Reference: MP10_0057 MOD1 /
11 August 2011

Modification Application MP10_0057 MOD1 for amendment to Conditions B5 and D1 of MP10_0057 at 132-138 Killeaton Street, St Ives

NRSP9452 - Site Entry & Exit Routes - Southbound vehicles - Mona Vale Road

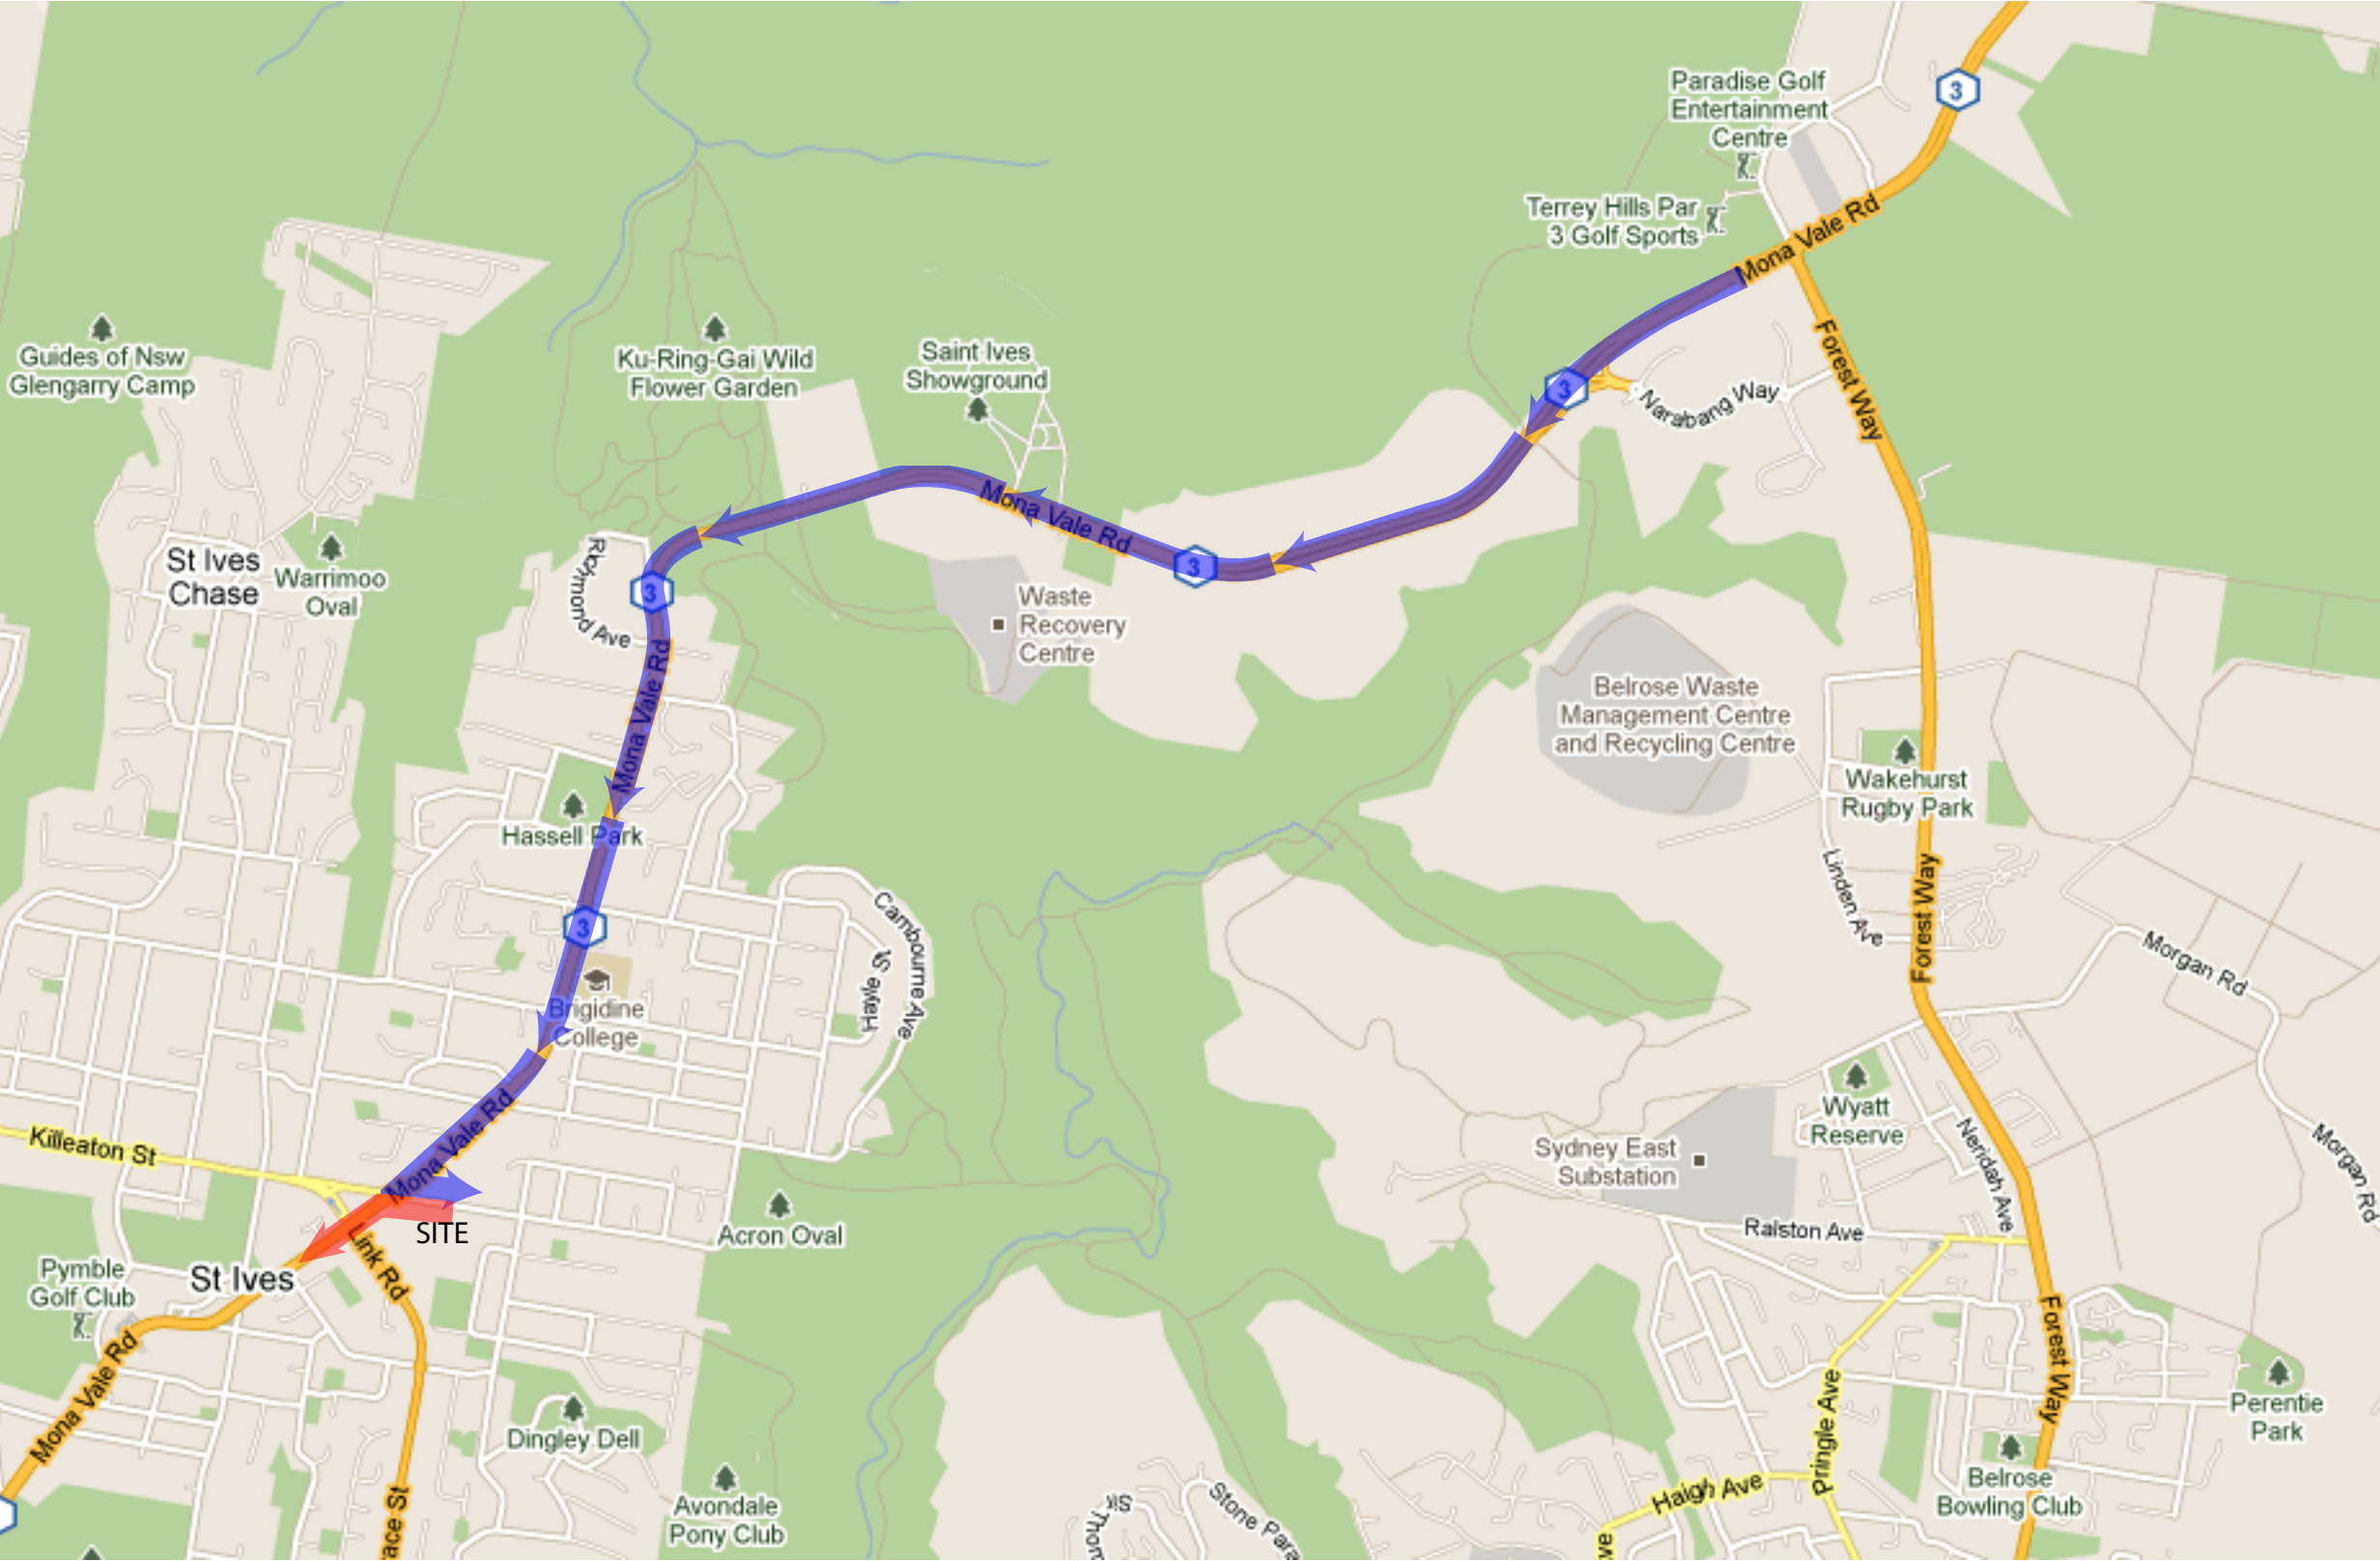
1. In Section 2.1 of the CTMP for vehicles leaving the site and travelling either north or south, the route is the same – left onto Killeaton Street and left onto Mona Vale Road. Where does the northbound vehicle turn around?
2. The use of Stanley Street may be preferable to Link Road because of the two schools on Link Road.
3. Section 2.3 - it is understood that a Works Zone has been approved – Council's letter of approval for the original CTMP includes the following statement "Upon completion of basement construction, you will be invoiced for the Works Zone and payment must be made and the signs installed before works proceed". The CTMP should be more specific about this.
4. Drawings NRSP9455/A and NRSP9456/A show a "No Parking" restriction opposite the site entry. This requires Traffic Committee approval. The applicant should be aware that sufficient lead time

Project/Event:	RESIDENTIAL DEVELOPMENT			
Location:	132-138 KILLEATON STREET, ST IVES NSW			
Client :	MERITON			
Plan No.	NRSP9472	A	Date:	28TH JUNE 2011
SCALE: NOT TO SCALE

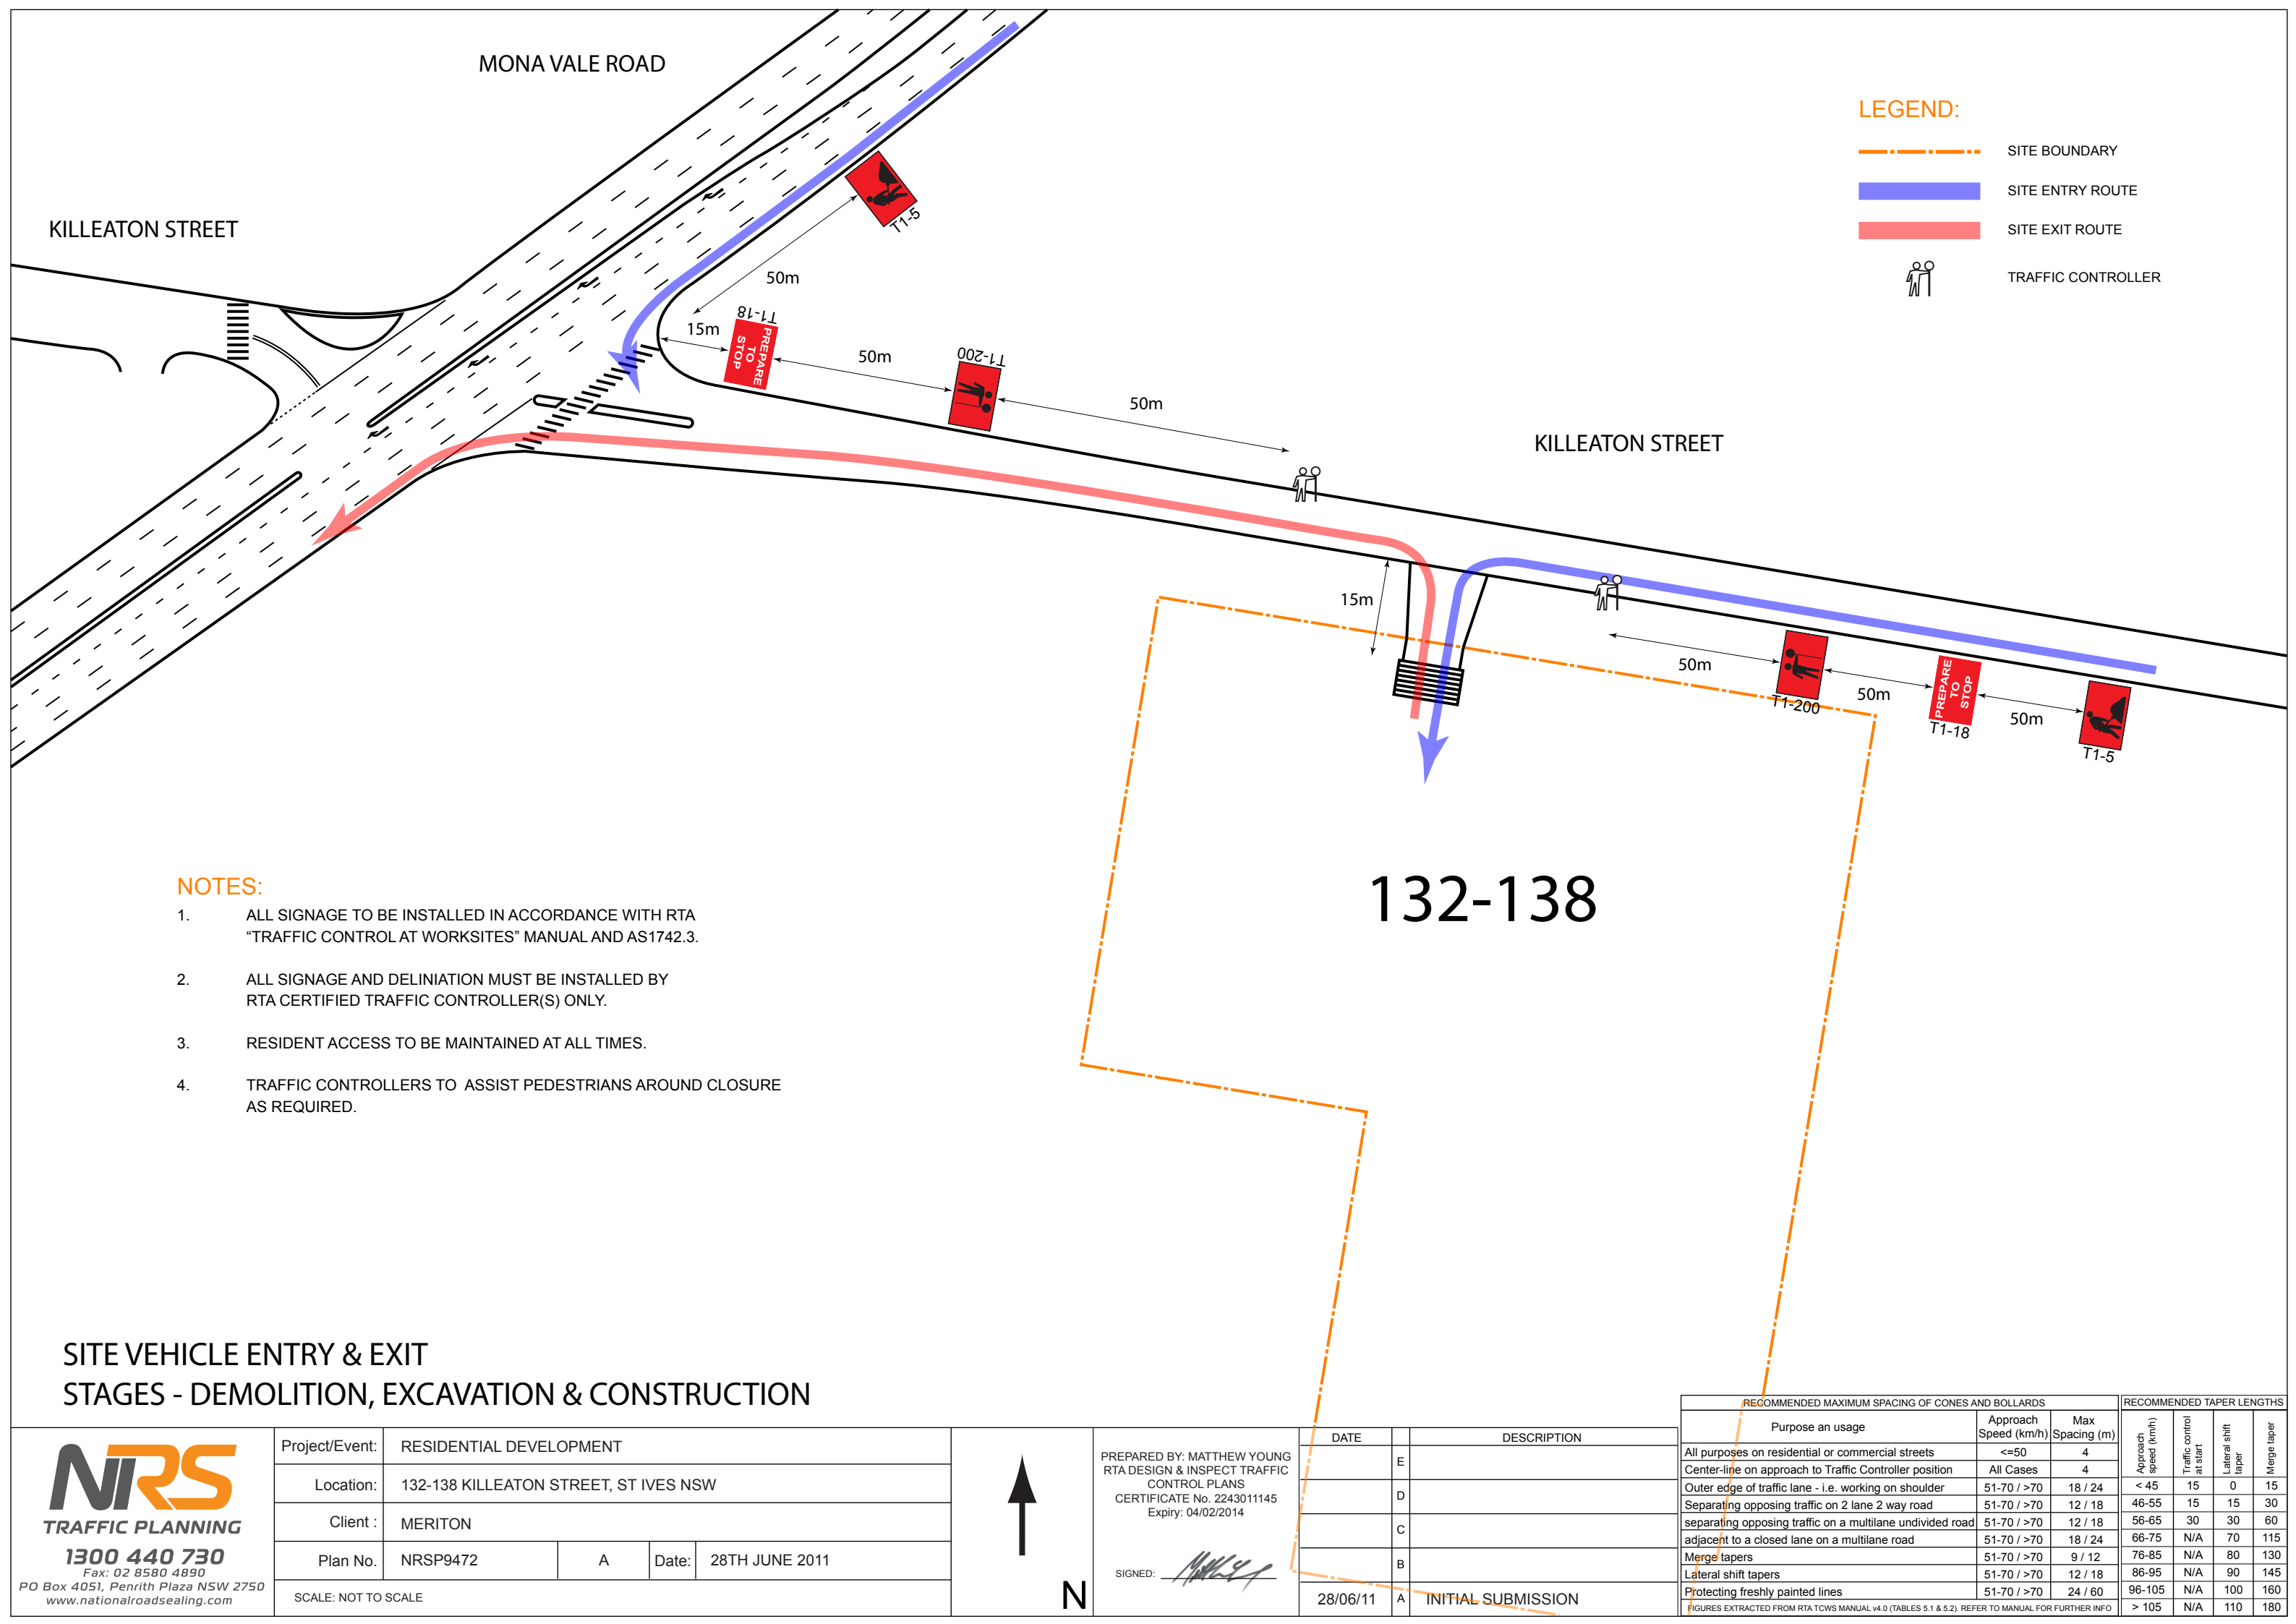
The proposal to utilise the existing driveway access located on the eastern side boundary is not supported due to the unacceptable impacts on Tree's 79-109. The vehicle entry and exit location approved under the consent and as indicated on the traffic management drawings submitted with the modification application should be maintained.
